Meeting note

Project name	North Shropshire Reinforcement
File reference	EN020021
Status	Final
Author	The Planning Inspectorate
Date	6 August 2018
Meeting with	SP Manweb
Venue	Temple Quay House, Bristol
Meeting objectives	Project update and review of draft documents
Circulation	All attendees

North Shropshire Reinforcement Project: Comments on the draft documents

KEY

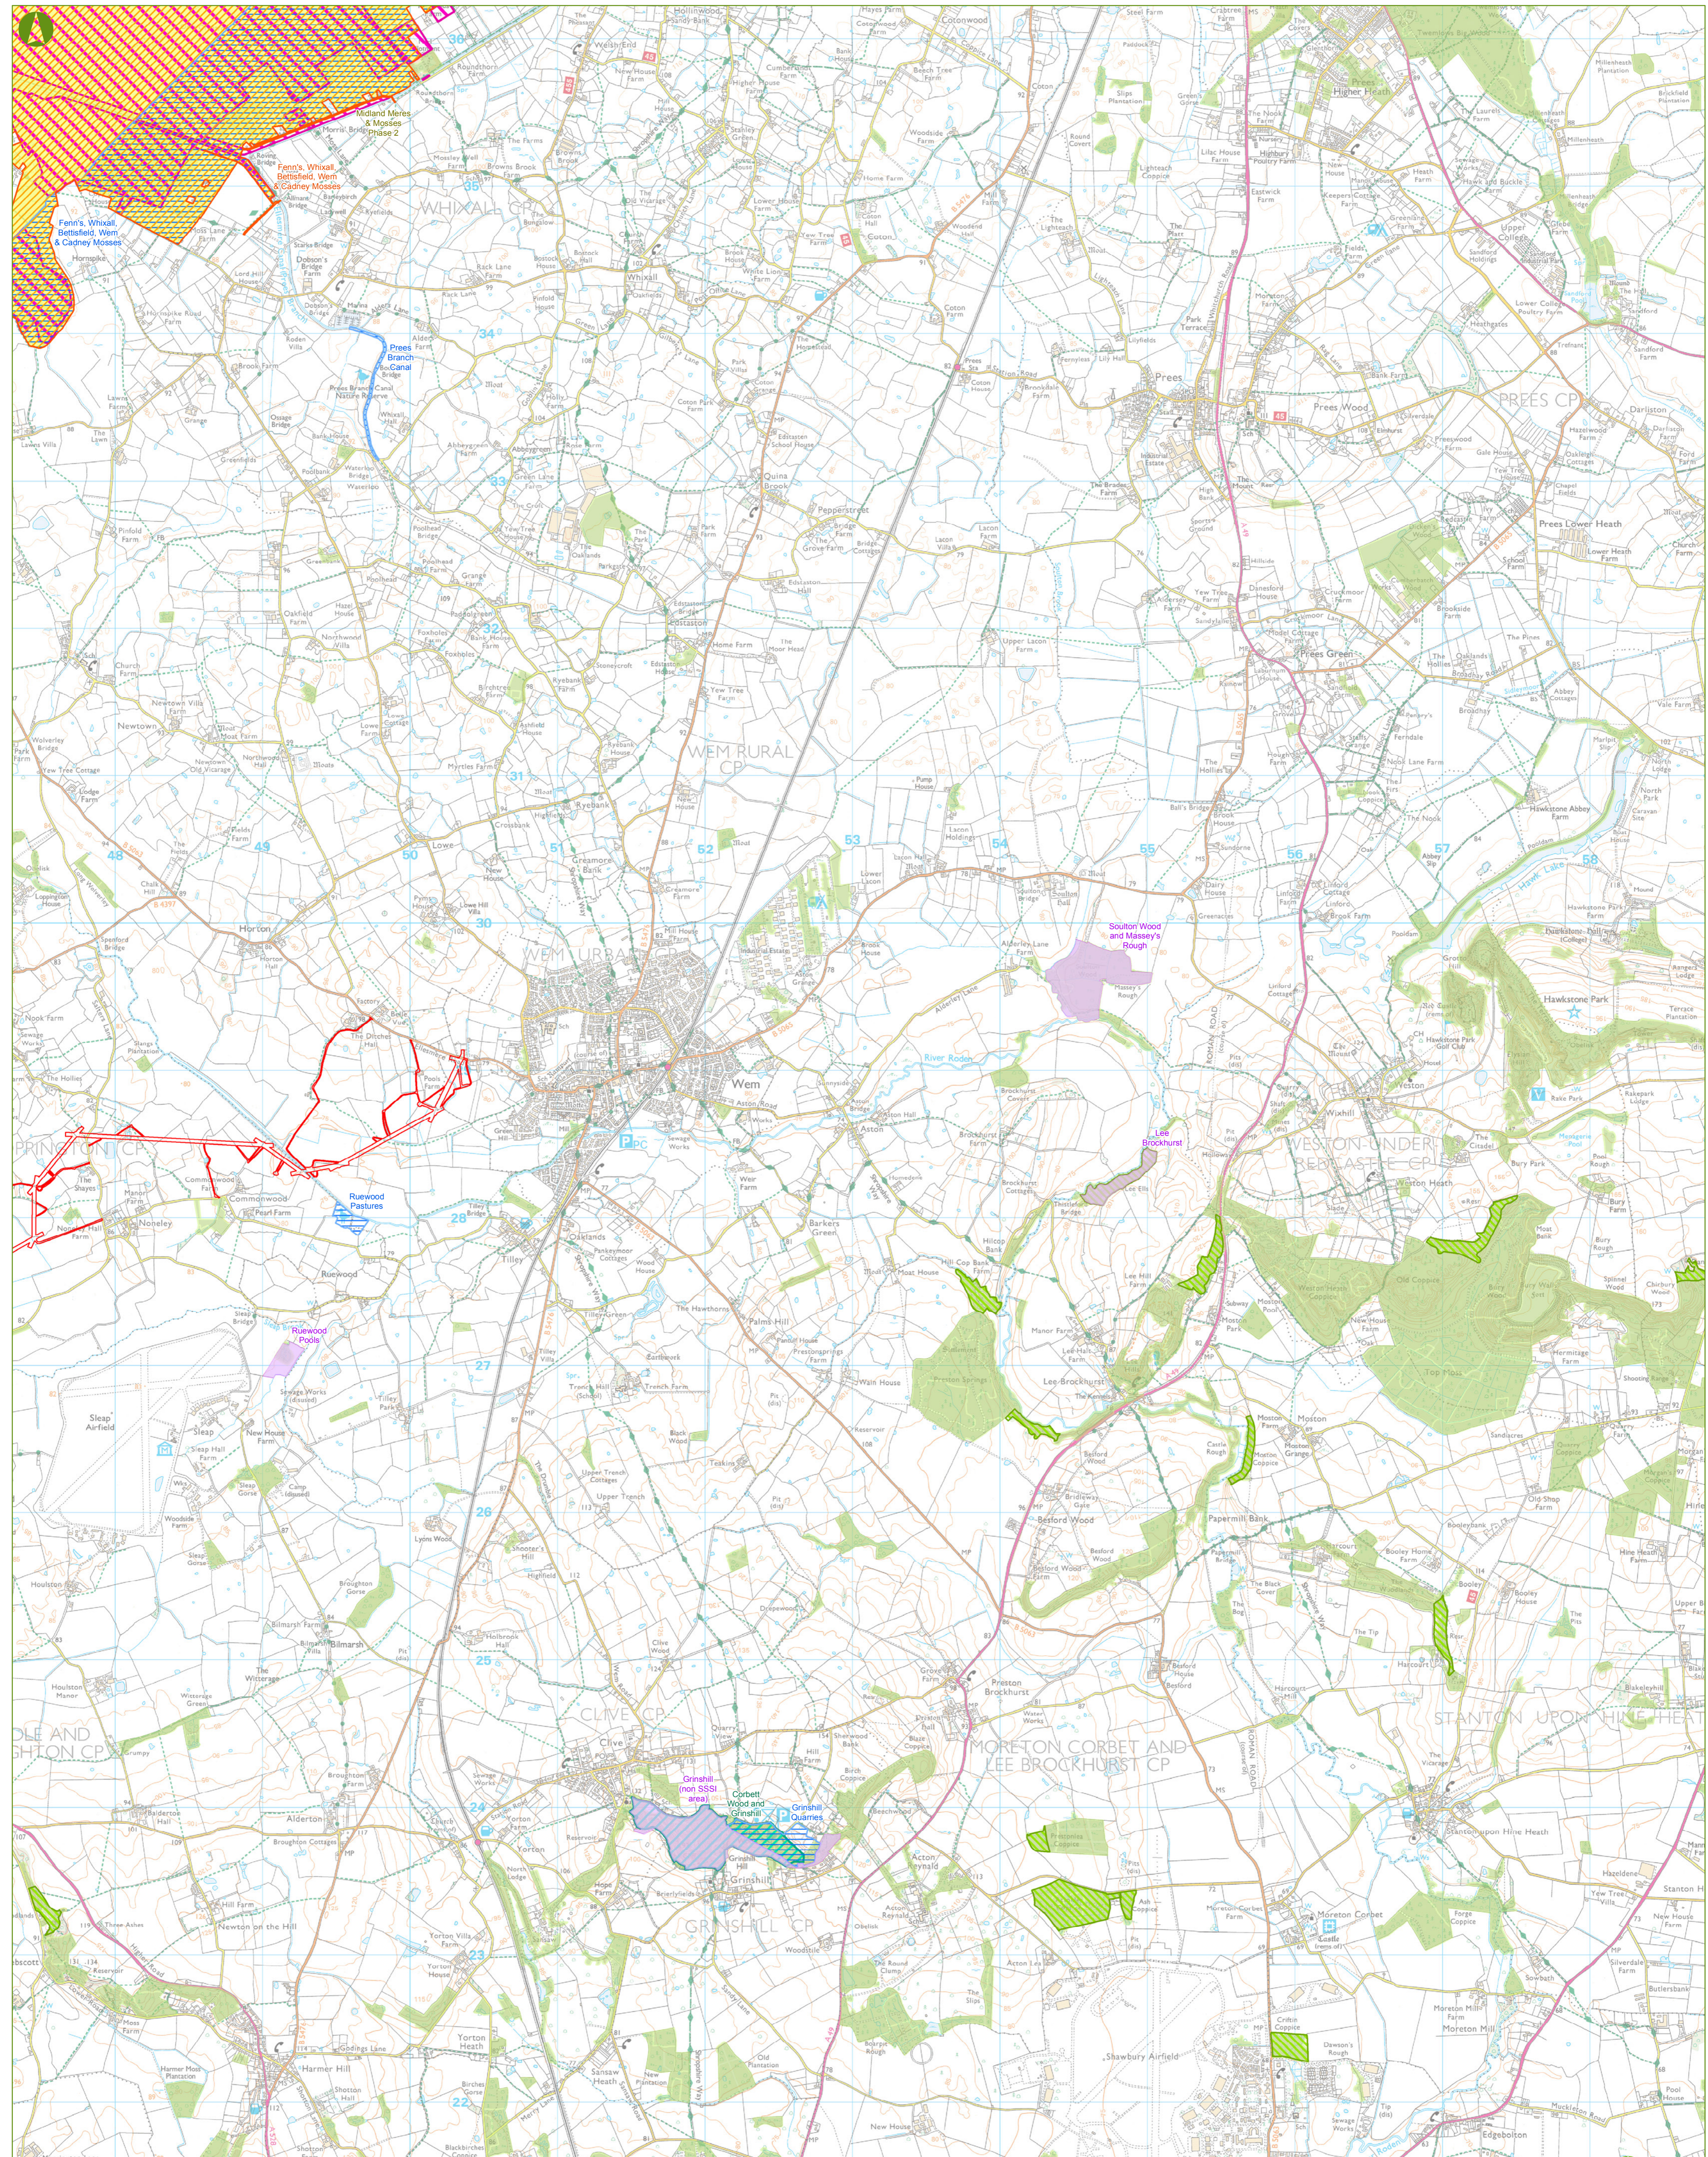
Historic Environment Sites Plan and Nature Conservation Sites Plan	<p>It is noted that these plans are not at the scale specified in the APFP Regulations however the Inspectorate will take a pragmatic approach towards this. We would advise you to justify this departure from the Regulations in the covering letter to your application.</p> <p>It would be helpful if any features that are identifiable by name are identified on the plans, e.g. by number matched to their name in the key/legend.</p>
Key plans	<p>Please ensure that plans that consist of three or more sheets also contain a Key Plan.</p> <p>Linear schemes in particular require a sequence of drawings to show the full extent of the proposals. Where sequenced drawings are provided a key plan and sequence notation should also be provided.</p>
PRoW	<p>These should be clearly marked so they can be cross referenced with the draft DCO.</p>
General Advice	<p>Please refer to advice contained in Advice Note 6 How to submit your application which provides advice on file referencing for each plan or document including, for example, the title, a unique plan or document reference and the appropriate APFP Regulation 5(2) paragraph number to which the plan relates.</p> <p>Any plans, drawings or sections should be consistent with the requirements set out in The Infrastructure Planning (Applications: Prescribed Forms and Procedure) Regulations 2009.</p>

Figure 1: Proposed Development and European 2000 Sites

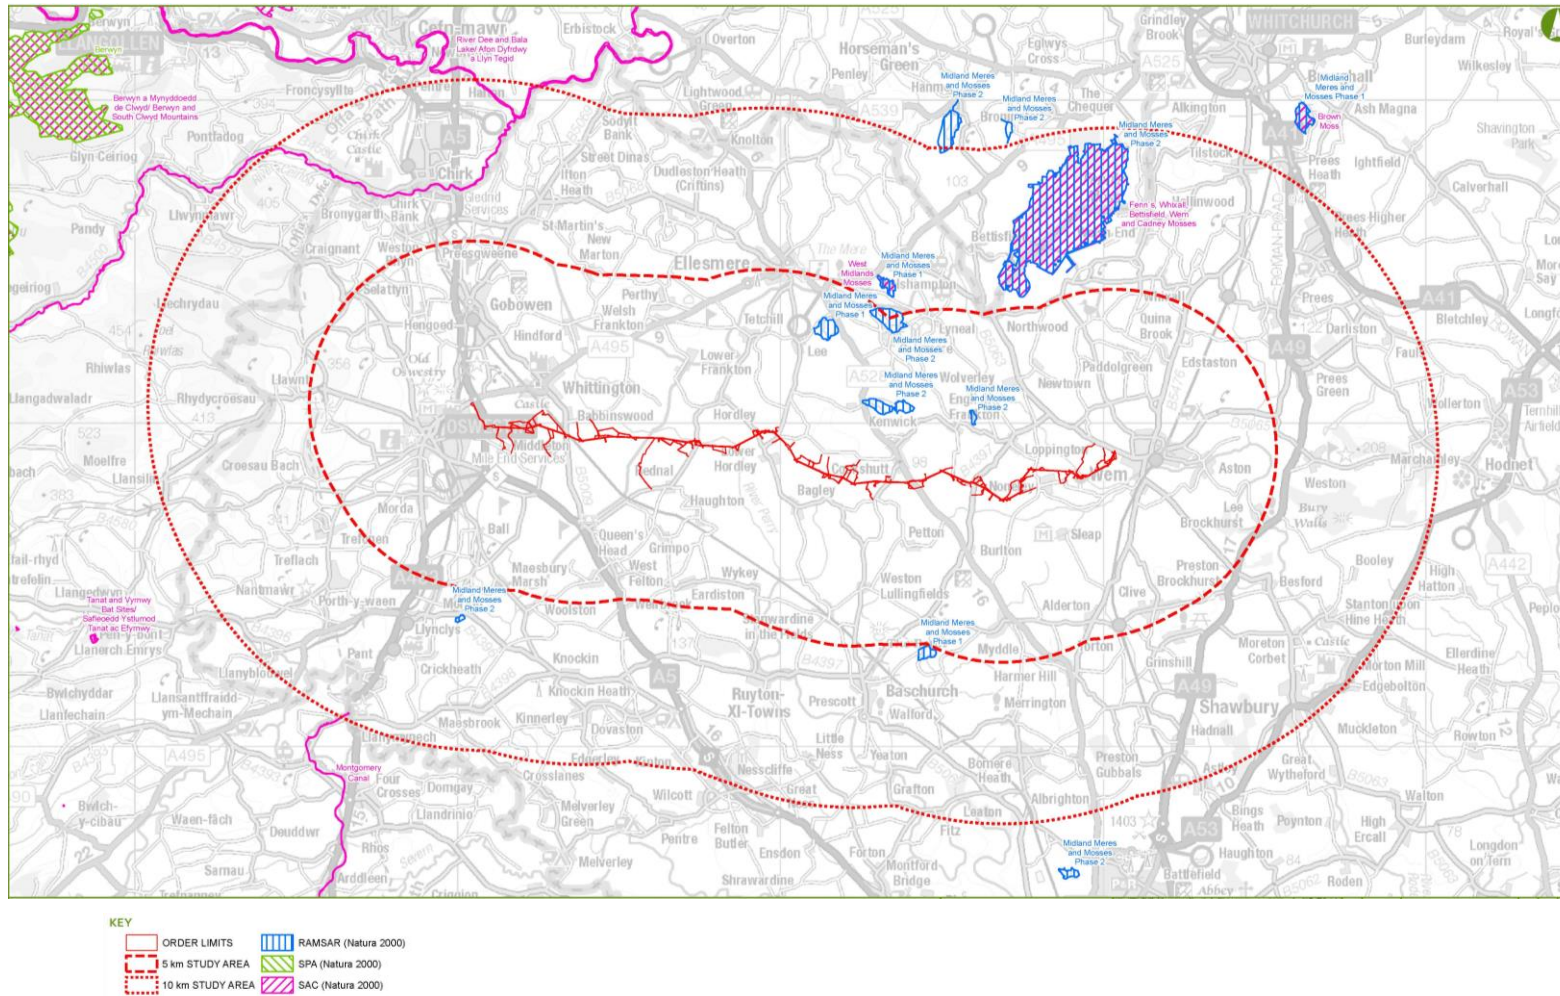
4.1.7 – 4.1.8	<p>There is no requirement to include information on Sites of Special Scientific Interest (SSSIs) in the HRA report.</p>
Figure 1	<ul style="list-style-type: none"> • The resolution is not of sufficient quality to easily read the text and understand the plan either in hard copy or electronically. • The European sites should be identified by name. • It is not possible to distinguish the revised preferred overhead line route and the proposed 25m corridor, as identified in the key. The plan should identify the European sites relative to the application site boundary. • The key is quite indistinguishable but appears to identify a 6km study area, although para 3.3.3 refers to a 5km ZOI. • It is unclear what the purple lines at the top and bottom of the plan are intended to identify. • It is not necessary to include the SSSIs.
Section 5.3	<p>Works and working areas are described as of limited or relatively short extent and duration, temporary, or small. Where known, dimensions and time periods should either be identified in the report or explicit cross-reference made to where the information can be found in other documents.</p>

Order Limits

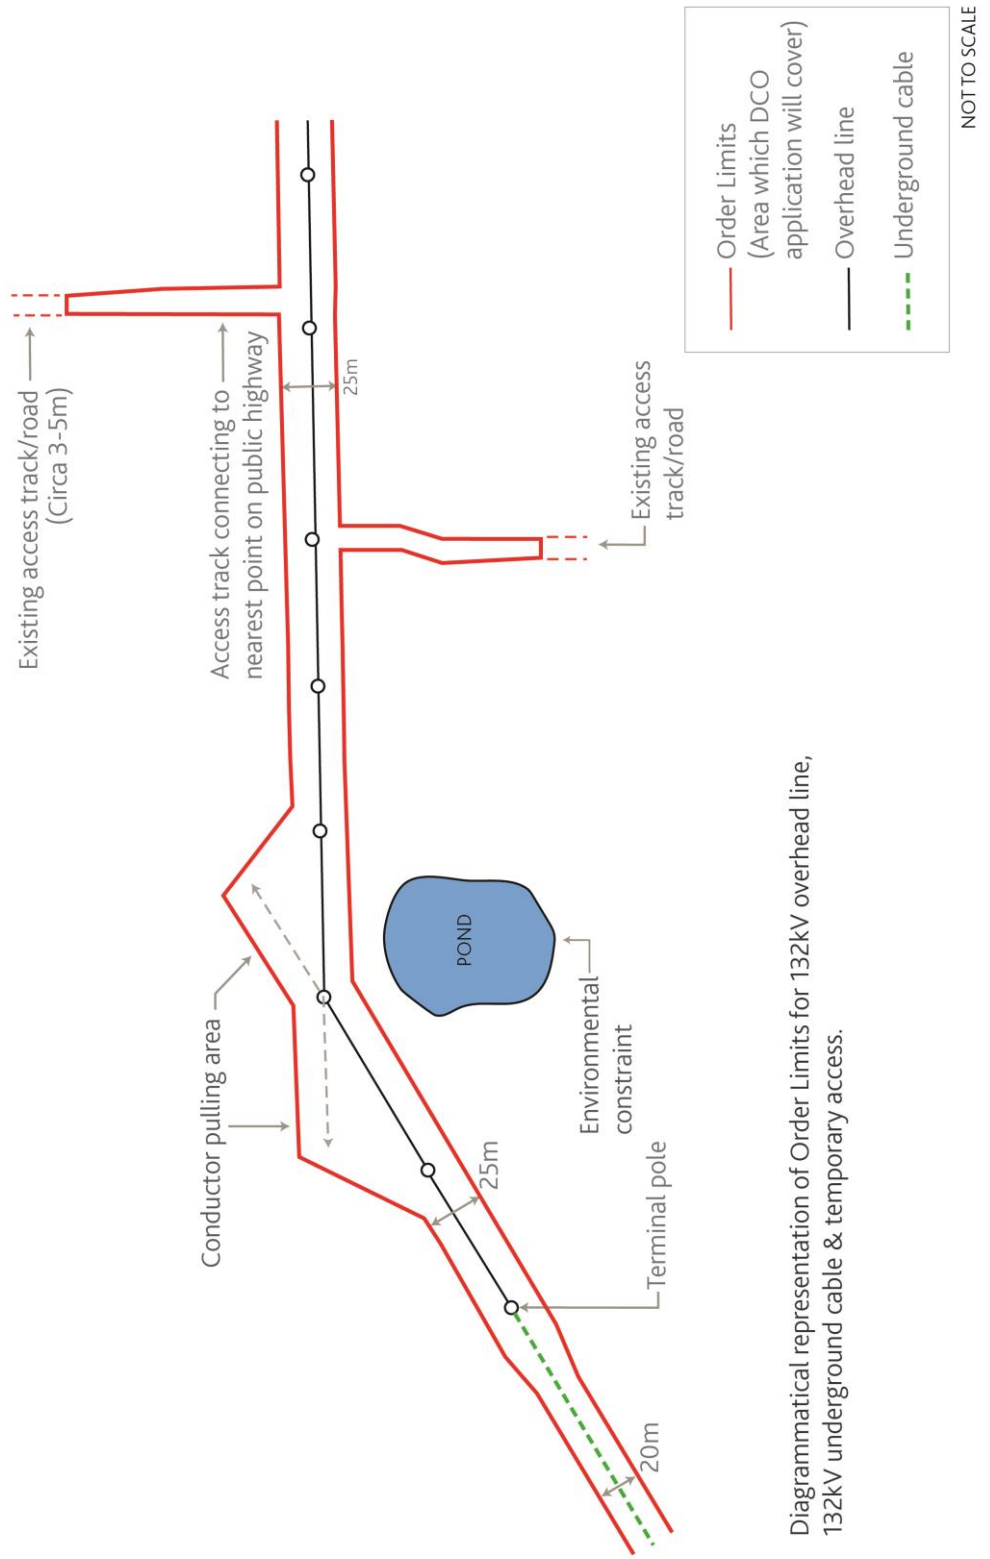
3.3.2	A reference is made to average widths of the route corridor. The minimum and maximum parameters should be clearly defined in the ES and consistent with those in the DCO.
Diagram 3.1	Figures on pages 5 and 17 are both titled Diagram 3.1 (and referred to as such in the text). It is assumed the Trident pole designs should be 3.2 (and that subsequent figures will need renumbering). The resolution of the Order Limits figure is unclear.
